memorandum

date September 20, 2016

from Scott Olmsted, Project Manager and Claire Hoffman, Ecologist; ESA

subject Proposed Mercer Island Center for the Arts (MICA) - Wetland Buffer Impacts and Mitigation Review

| SHEET NUMBER: W1 OF 1 | SHEET NUMBER: W1 OF 1 |

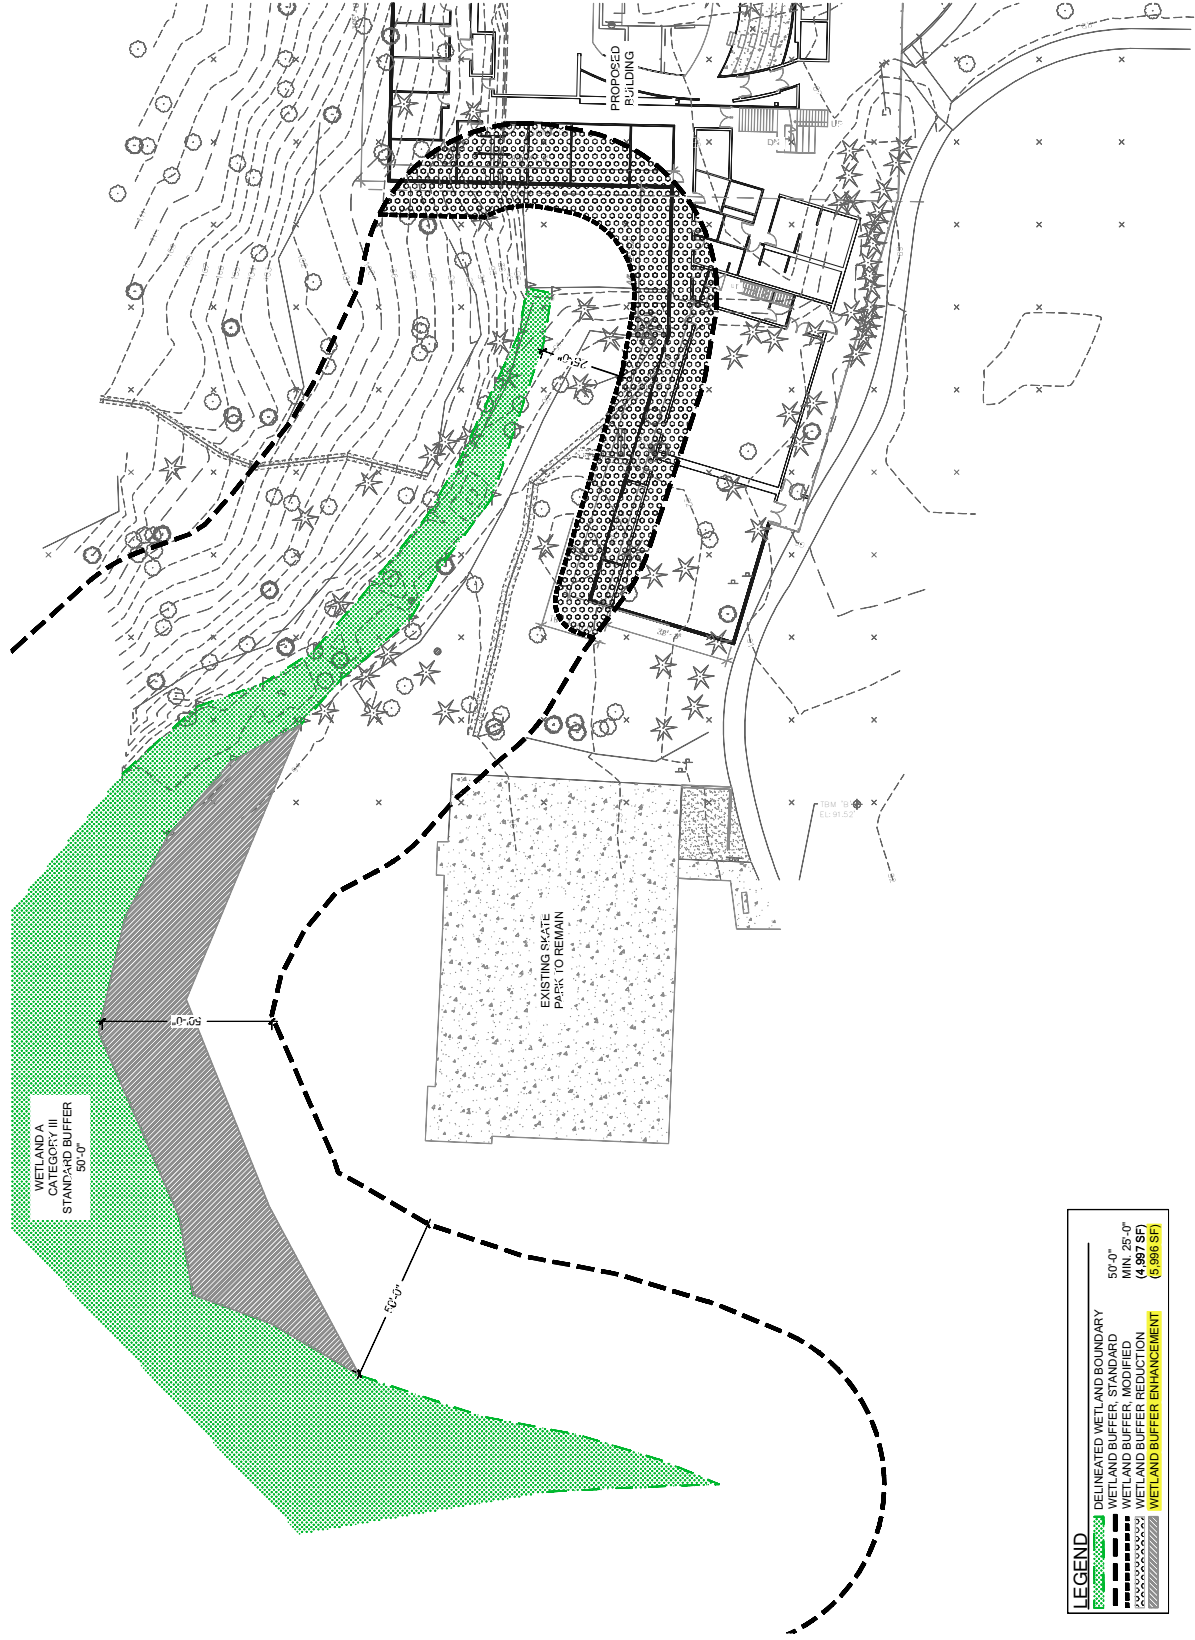
Sheet W1 of 1 shows a buffer reduction at the north end of the wetland. The buffer will be reduced from 50 feet to 25 feet, which is the minimum width allowed MICA 19.07.080(C)(1). Buffer reduction would reduce the buffer area by 4,997 square feet. Proposed buffer reduction activities should be documented in a buffer mitigation plan. The proposed buffer reduction must account for the bioretention area and access road “stub” as described above.

To mitigate for buffer reduction, the applicant proposes to enhance 5,996 square feet of buffer located about 80 feet south of the reduction, adjacent to the east side of the wetland (Sheet W1 of 1). Buffer enhancement is an approved mitigation activity that offsets loss of buffer functions associated with buffer reductions MICA 19.07.080(C)(2). To better understand if the proposed mitigation complies with MICA, the applicant should provide a more detailed mitigation plan. ESA recommends a buffer mitigation plan that provides applicable information listed in MICA 19.07.050(C).

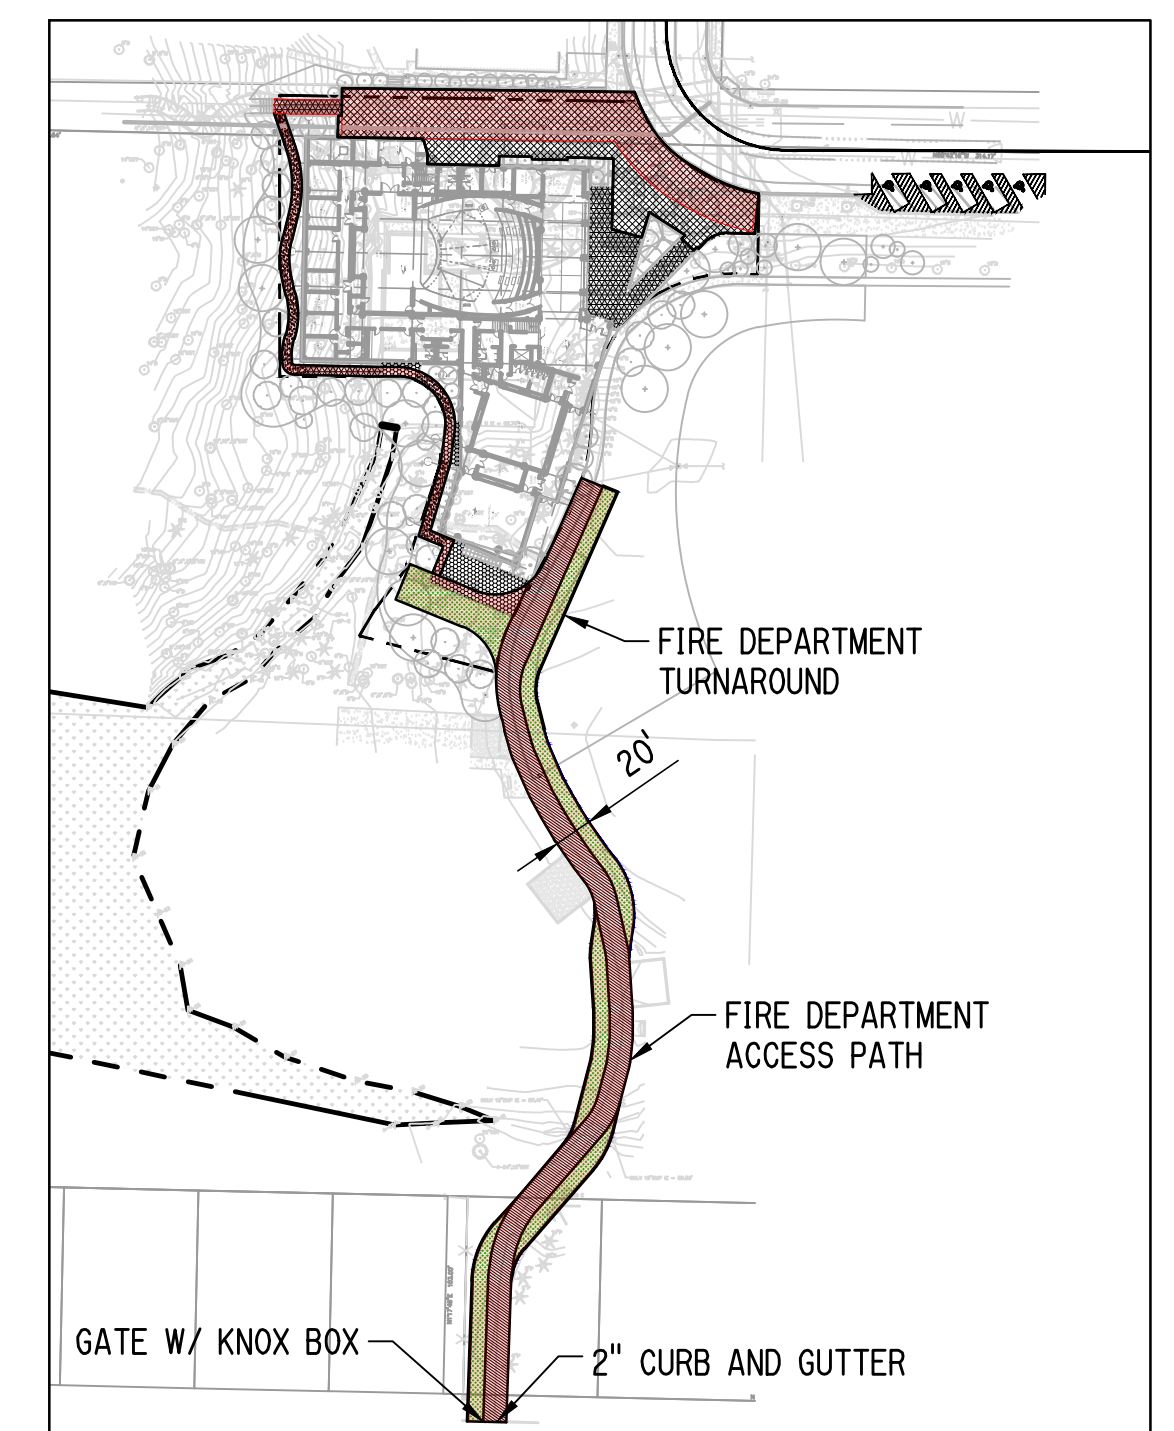
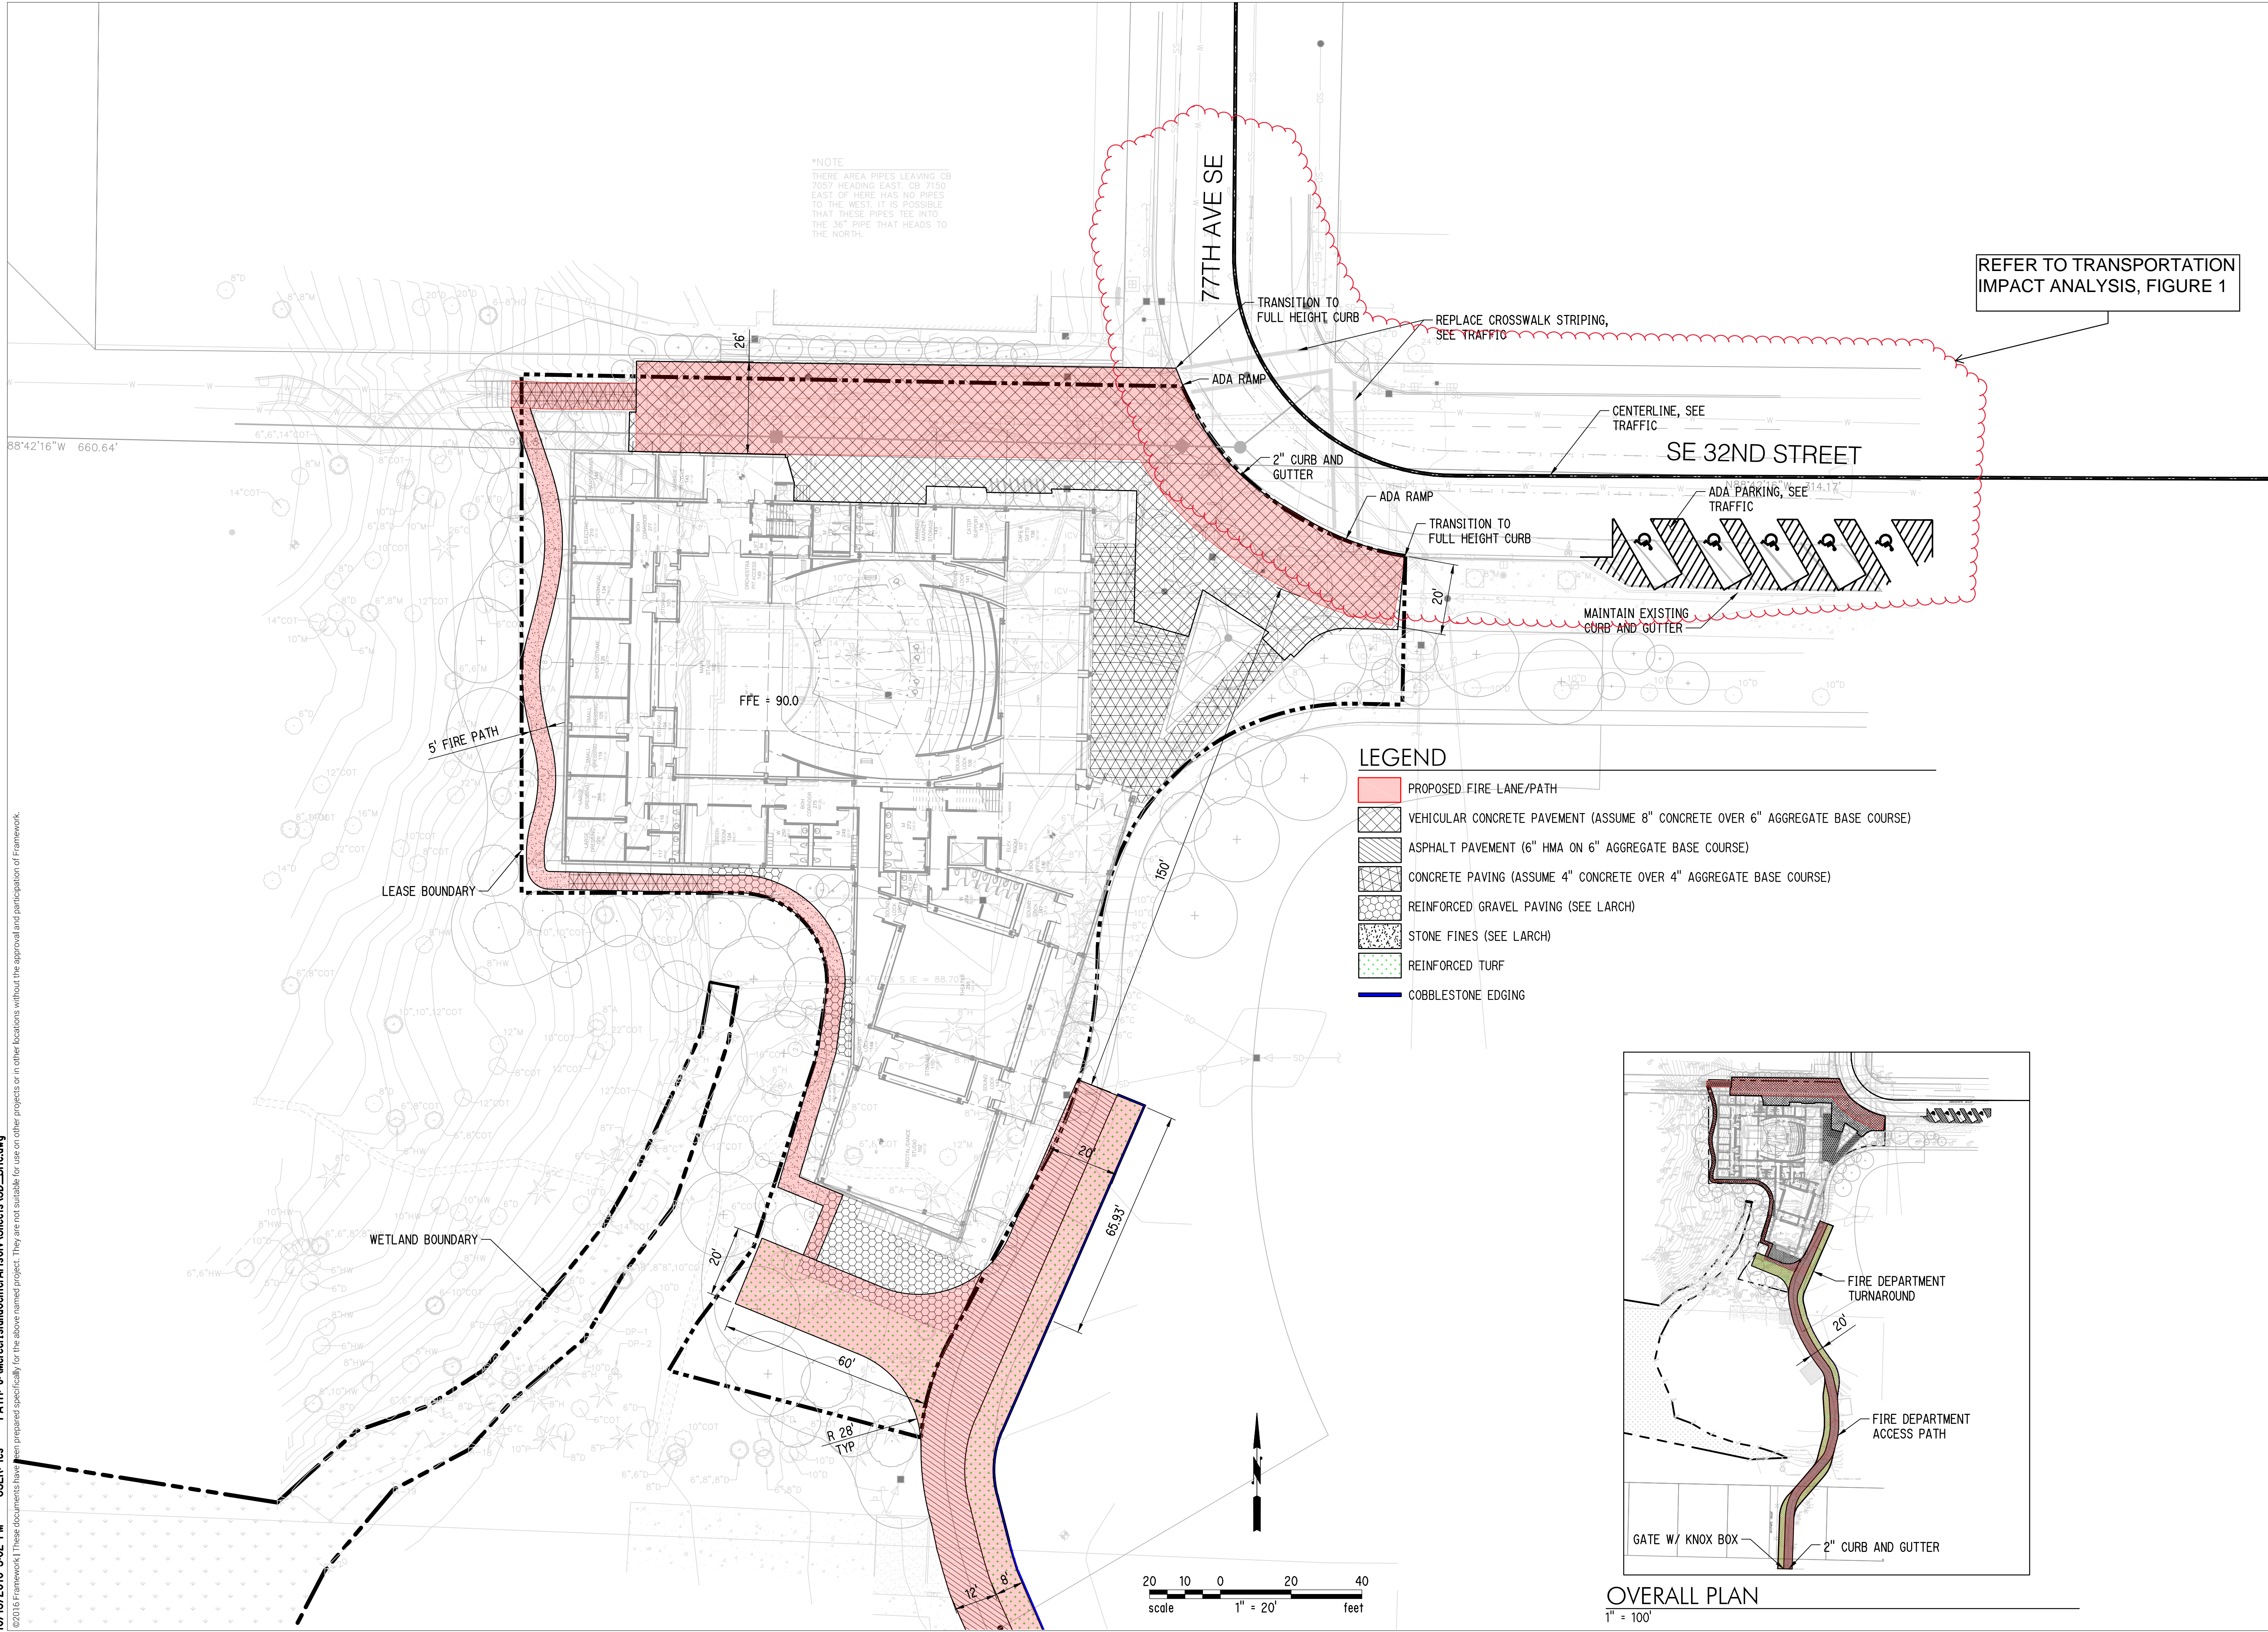
The project proposes two features that would discharge water directly into the wetland: 1) a swale located west of the proposed building and 2) a wall drain located on the south side of the building (see Sheet C302 Offsite Storm Drainage Plan). Potential impacts to the wetland resulting from these proposed discharges (e.g., altered hydrology, scour) was not evaluated in submittal materials; therefore, ESA recommends that such an analysis be included in the stormwater management plan and/or wetland buffer mitigation plan. The analysis should include the volume and quality of water expected to discharge from these structures.

A proposed storm drain connected to the existing storm drain system will pass through a new underground stormwater detention vault and discharge to a new bioretention cell located at the south end of the proposed building. The proposed bioretention cell is partially located within the 50-foot wetland buffer. MICA does not restrict the placement of bioretention cell in wetland buffers; however, buffer impacts associated with the bioretention cell have not been evaluated or mitigated. The applicant should describe wetland buffer impacts, and detail how impacts will be mitigated. Further, an access road “stub” north of the bioretention cell area is shown on Sheet C502 Offsite Storm Drainage Plan which also encroaches on the 50-foot wetland buffer.

Sheet C502 (Offsite Storm Drainage Plan) indicates the proposed swale will continue into the wetland and the wall drain will be located with the wetland boundary. The applicant should confirm that no grading is proposed within the wetland and no fill material will be placed within the wetland boundary. If grading is proposed within the wetland buffer, these impacts (temporary and permanent) should be described.
